Online Comment

Application H08-0954-25
Location Riseholme Farm Gosberton Risegate PE11 4ET
Proposal Proposed Detached 4 Bed Dwelling

Name Imogen Colenutt, Assistant Conservation Officer
Address Council Offices The Hub Mareham Rd LN9 6PH

SHEET
Proposed Block Plan

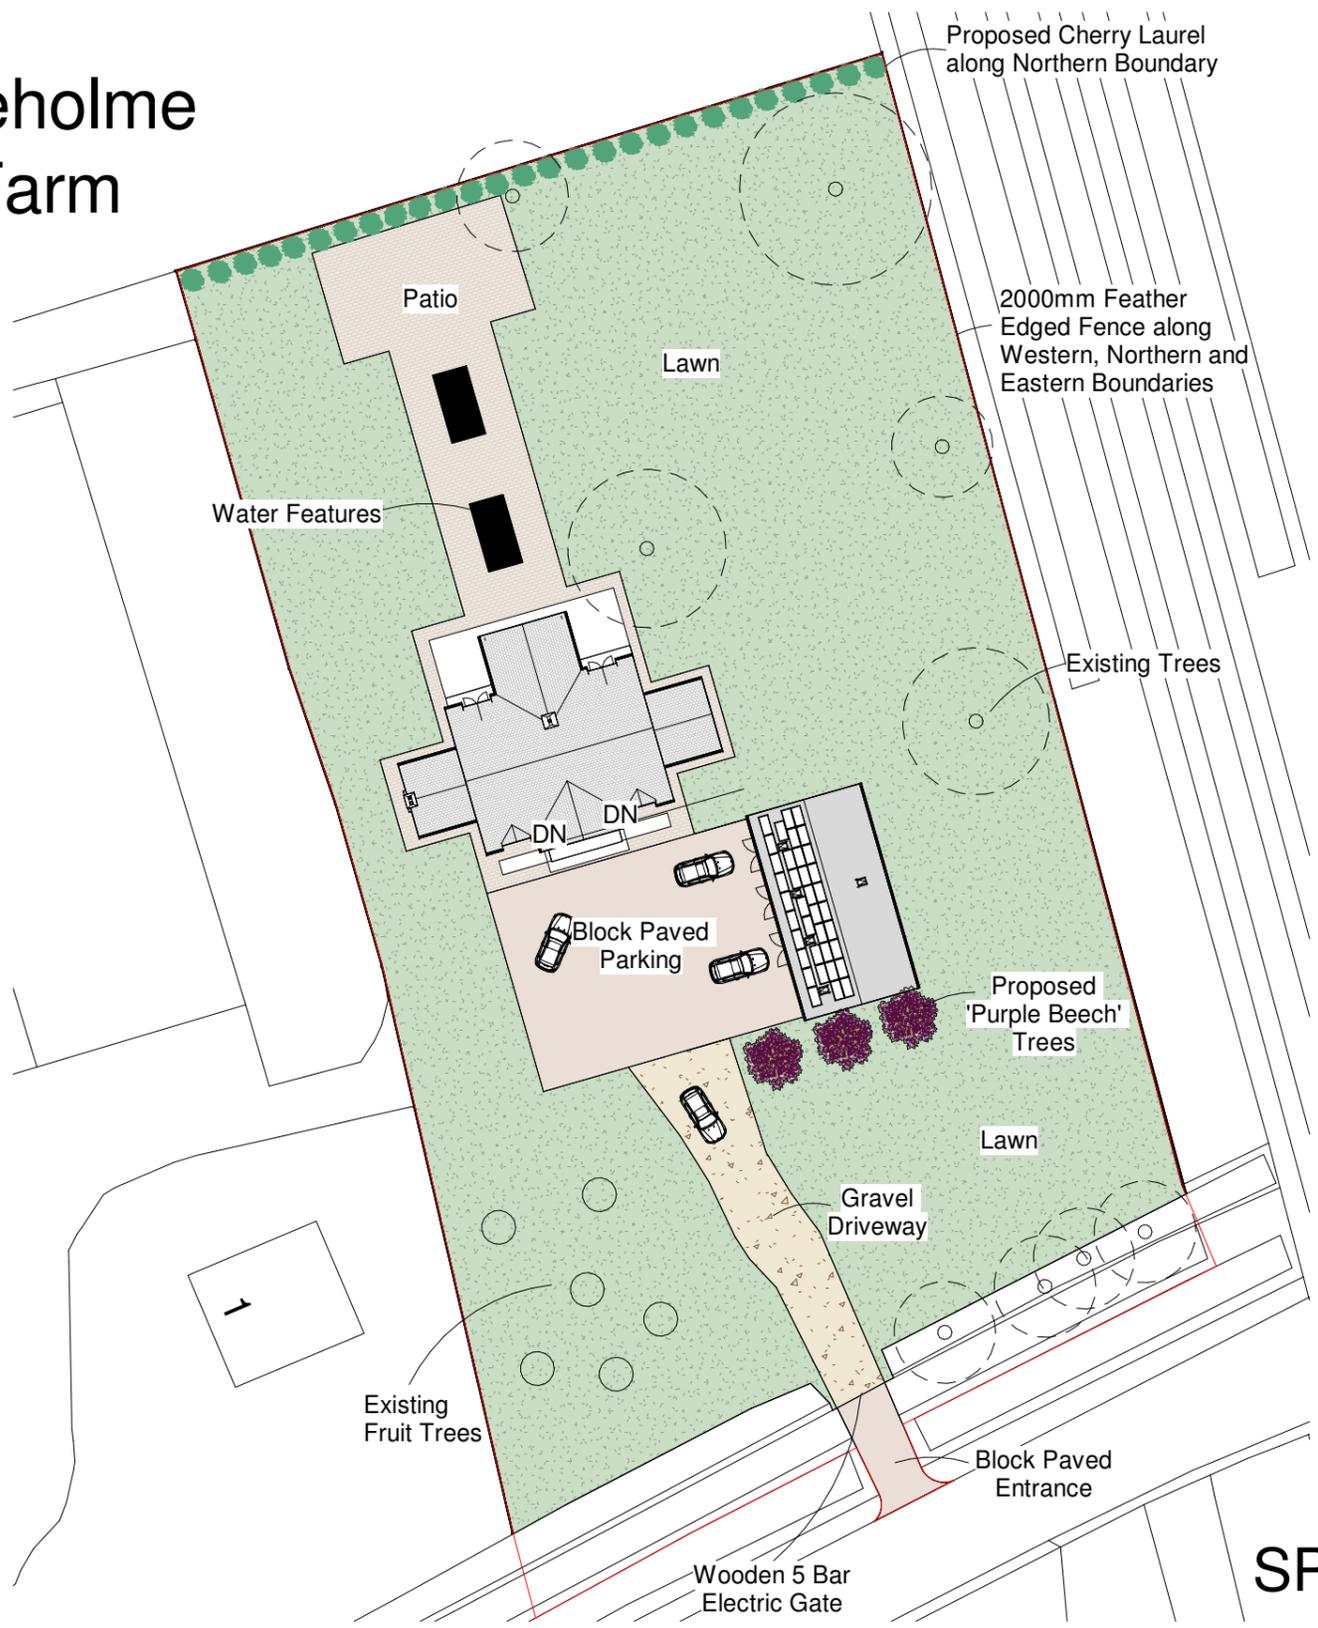
However, I do have some concerns about the proposed 2 metre close board feather edge timber fence around the property as well as the 5 bar gate. This type of boundary would create a solid, enclosed appearance that feels out of keeping with the rural character of the site and its surroundings. The NDHA's setting is defined by its open and agricultural context, and a tall, close board fence would appear at odd with this.

Many nearby properties have more open frontages, with hedgerows, post and rail fencing or low boundaries which creates a village 'theme'. Including the proposed fence would therefore have a negative visual impact on the overall aesthetic of the area.

To help the proposal blend better with the surrounding area and to lessen any potential impact on the NDHA, I recommend that the boundary treatment be reconsidered. Using a hedge or a more, lower and open form of fencing would sit more comfortably with in the setting of the NDHA and wider character of the village.
